Helios EN010140

**Reg 20050592**

Expanding from my published submission, 28 February 2025. Updated 18/03/2025 with Questions.

### The Battery Energy Storage System (BESS) plus the 132Kv Sub Station

Environmental Statement Figure 11.4: Noise Contour Map Daytime

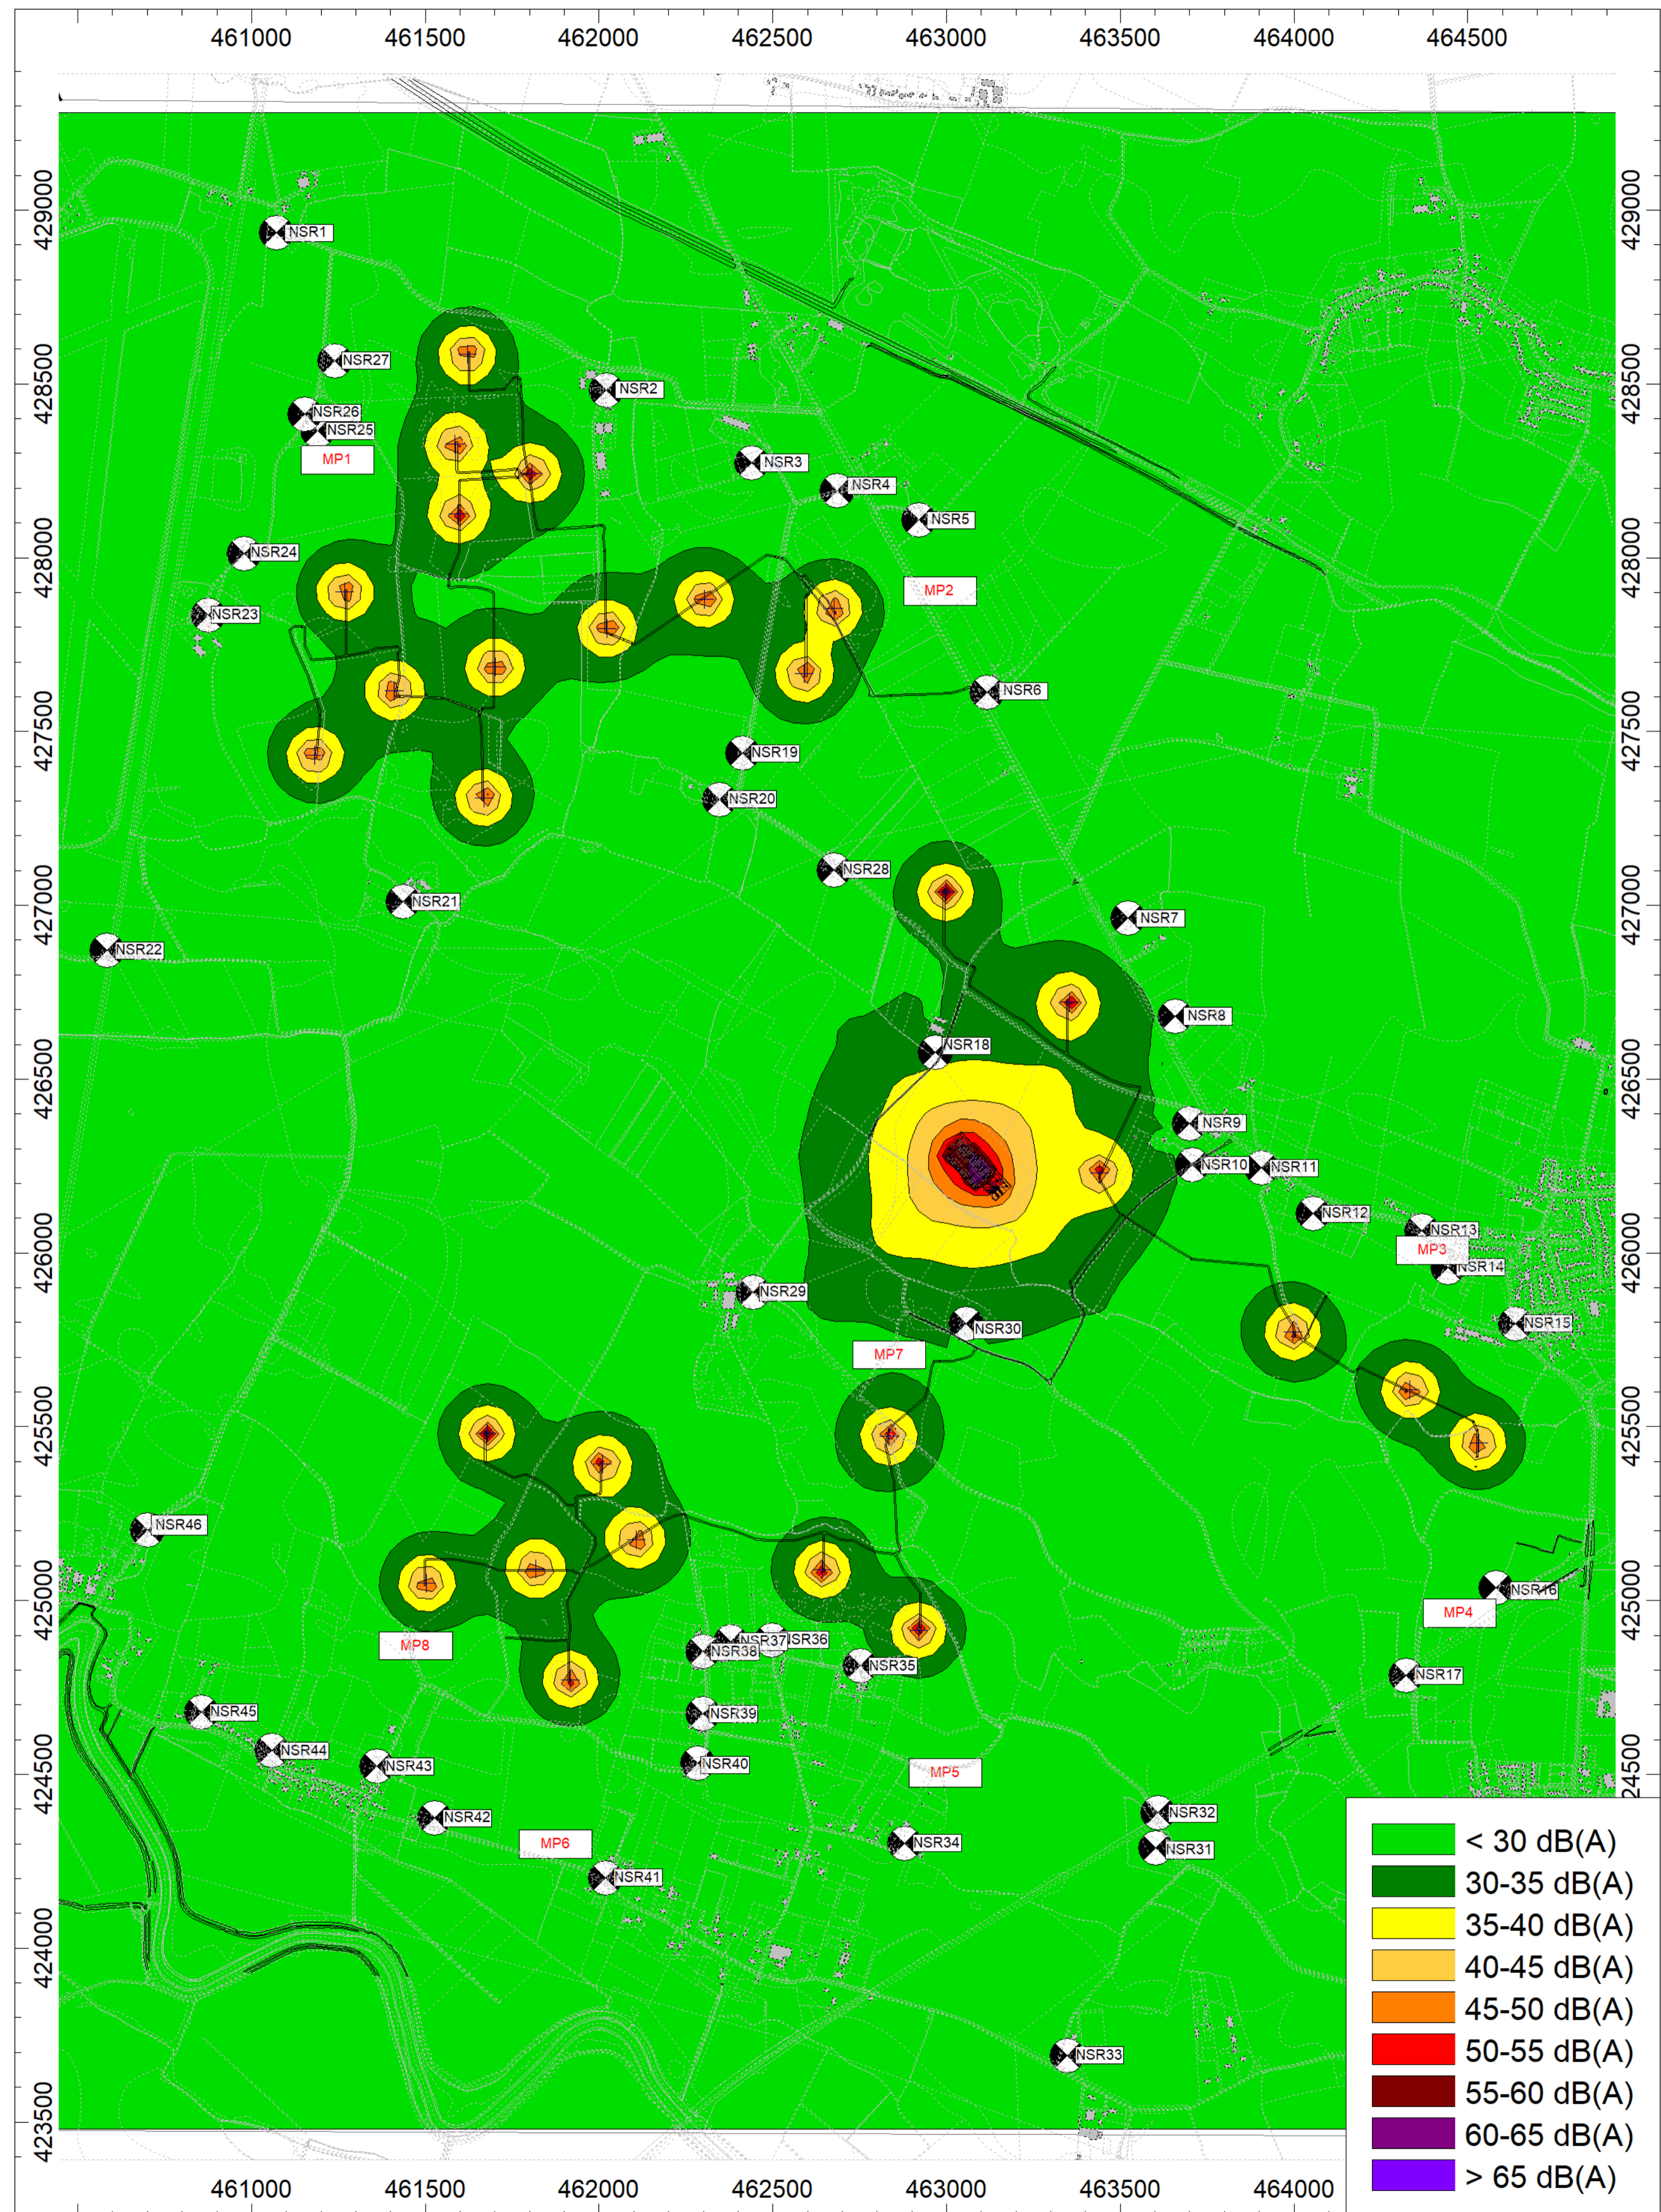
### With Reference to Environmental statement Figure 11.4

**(The map I have supplied number 7), has a symbol Z? which I have added. Whatever it/they are. (counted 28) They have the capability of emitting 45-50 dB of noise. The Z? in question is ALMOST AT THE BOTTOM OF MY GARDEN.**

**Due to the poorly detailed map, I could not get a Fix position to measure approx., how close it is.**

#### **1.a What are these?**

### Also With Reference to Environmental statement Figure 11.4

#### **1.b**

**On the poorly detailed Map Fig 11.4 – Noise Contour Map Daytime, (my ID Map 7). I would like some independent assurance, that *as if by some miracle*, we are in the **< 30 dB zone.****
